MEMO

22 August 2011

Greenspace Engineering and Emergency
Planning

**THE WOODGATE CENTRE WOODGATE ROAD WESTERGATE PO20 3GU – AL/69/11
AL/70/11**

KEY

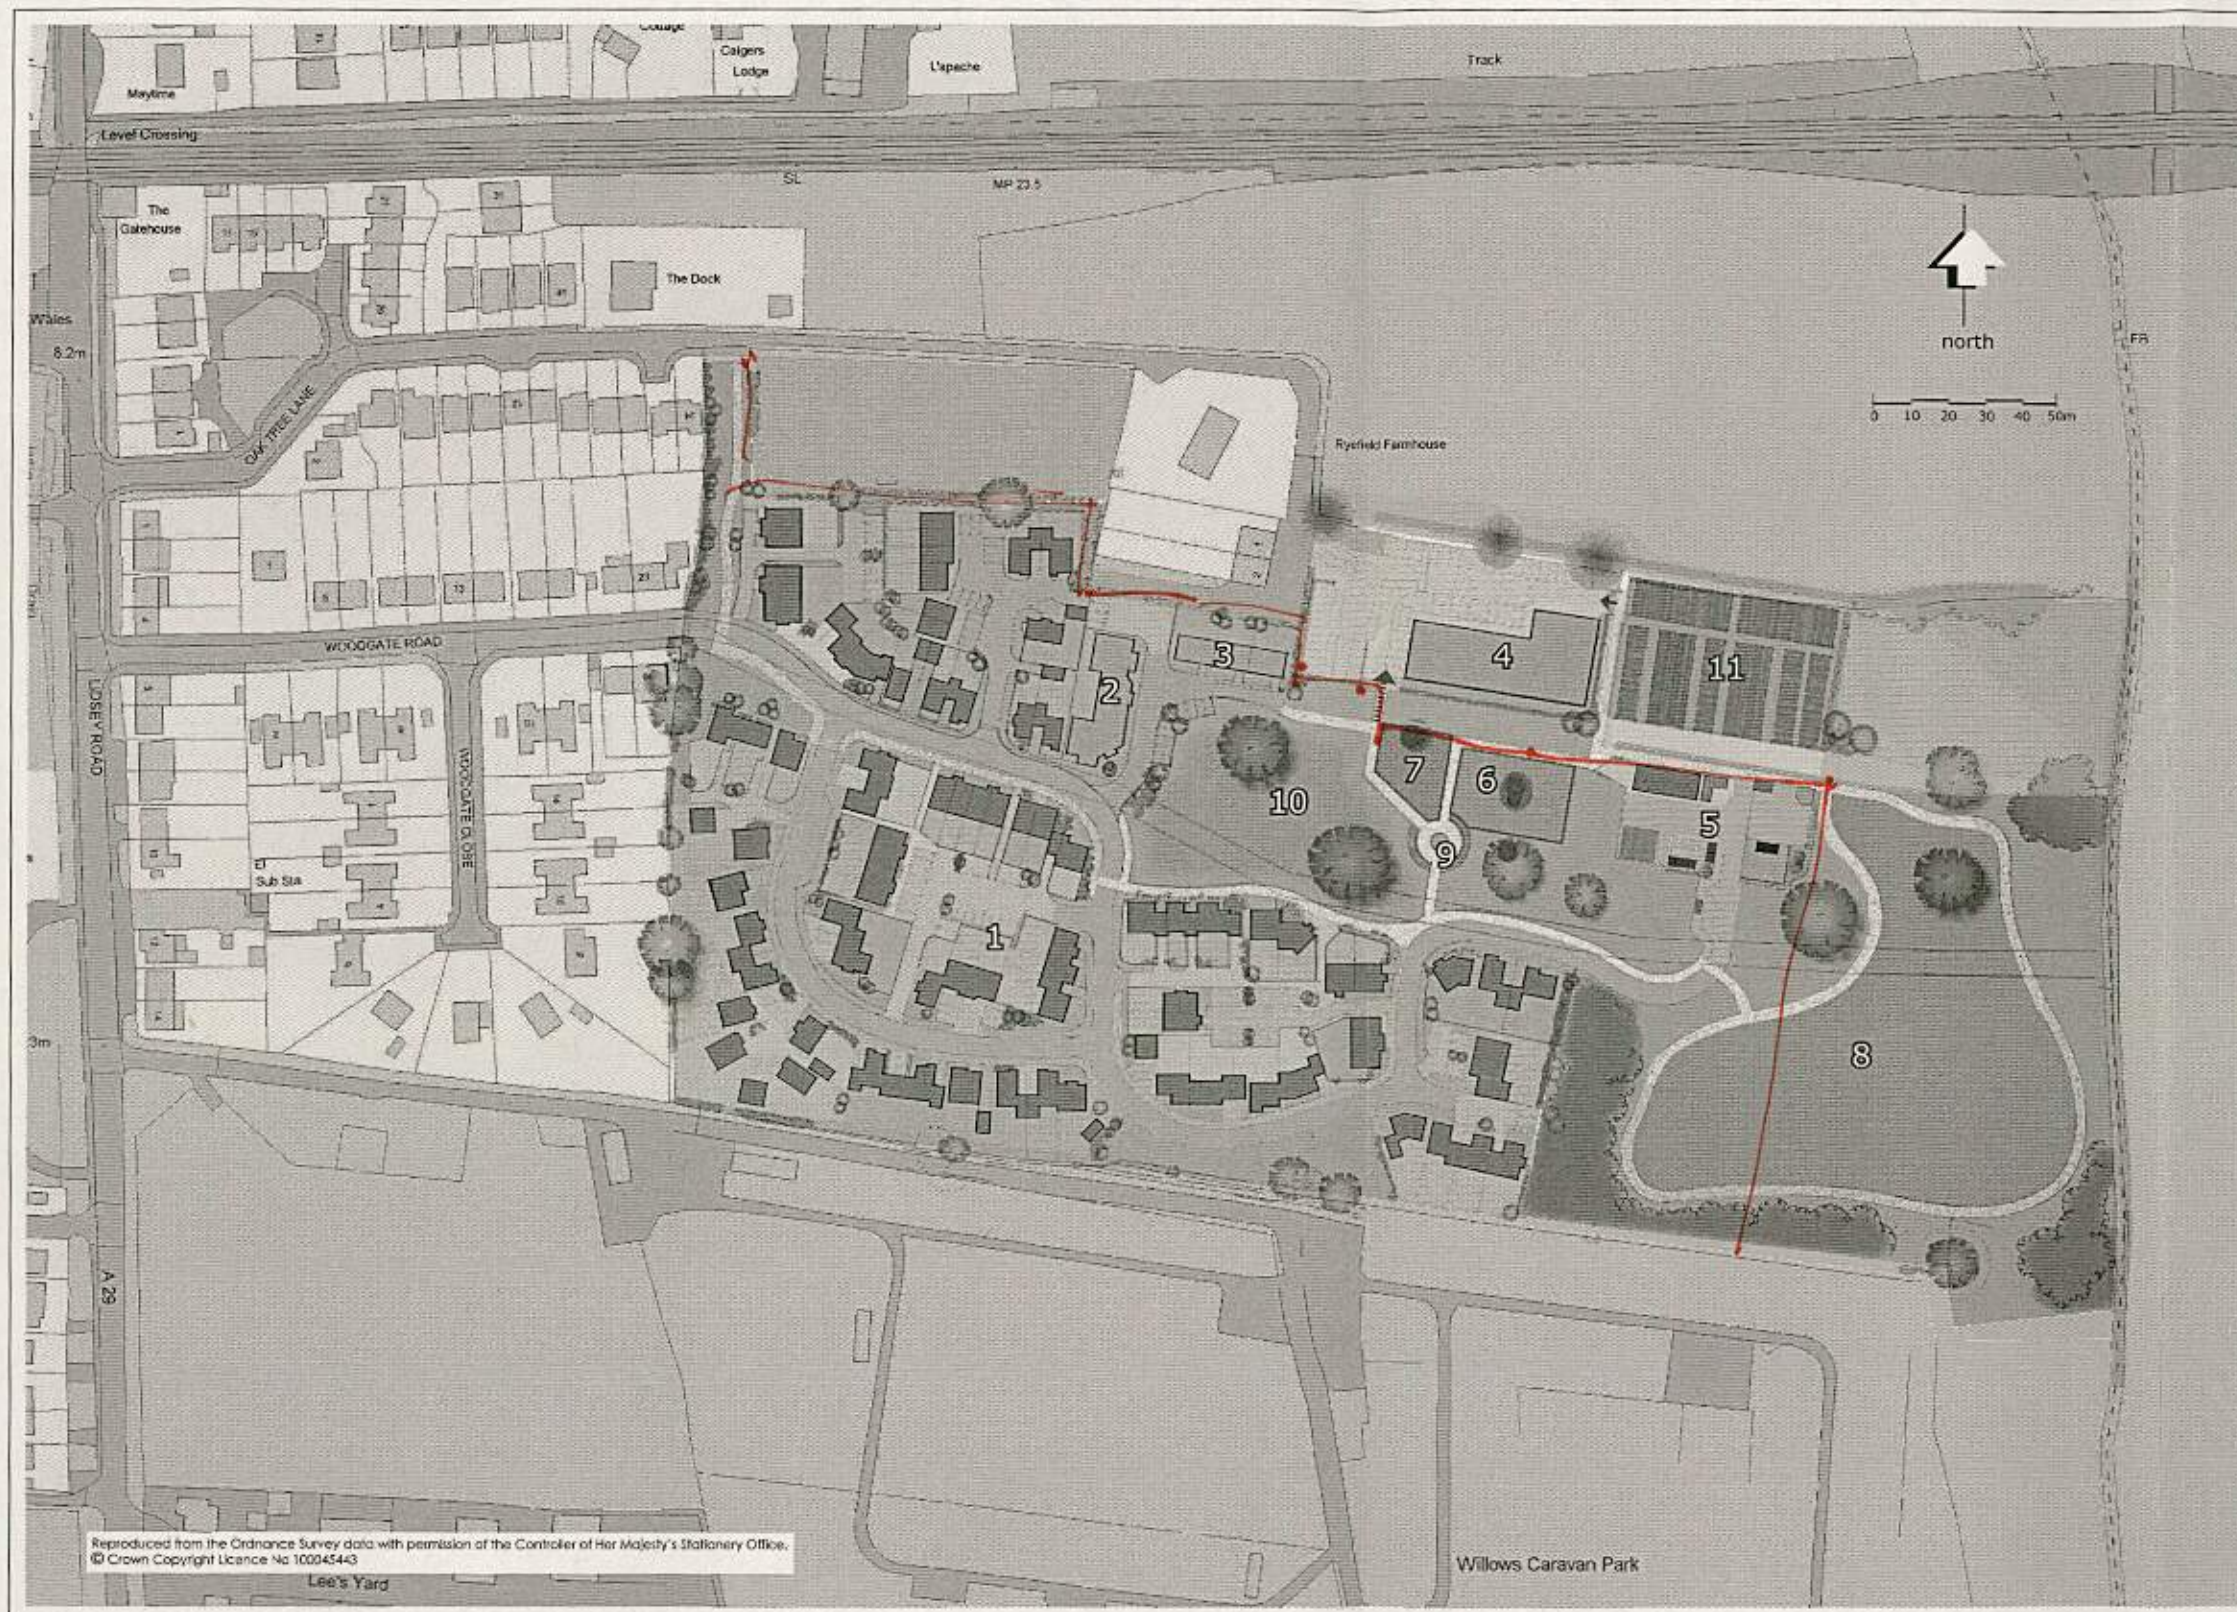
A development of up to 100 houses will produce a population of 220 people. There is a requirement of an area of 9262 m² of public open space with this development. The figure stated as being provided at 7115 m² within the red edge of the development is therefore insufficient. The adjacent open space area is noted, but unless the red edge is extended to include part of this area the proposal in terms of open space provision is inadequate.

It is noted that the open space areas have been centred around areas where trees exist on site which appears a sensible approach. However this has resulted in several fragmented areas. This together with the requirement for a large area of the open space to be for outdoor sports and that there is currently an under provision underlines that the proposed open space provision is inadequate.

The provision of play for the development is adequate. The location near housing is questionable, their location is critical to their success or failure. They must be located allowing a buffer of POS between these areas and housing, in accordance with FIT standard (formerly NPFA). The detail of provision would need to be conditioned or form part of a reserve matter with any permission.

No information on whether SUDS form any part of the open space areas; by their nature they are included with POS areas. The full implications of any scheme must be provided to ensure this sits well with any POS provision. This information must be provided as part of the outline application.

Only minor indicative planting has been illustrated with the plan and is therefore inadequate. This would result in poor quality open space as shown at present.
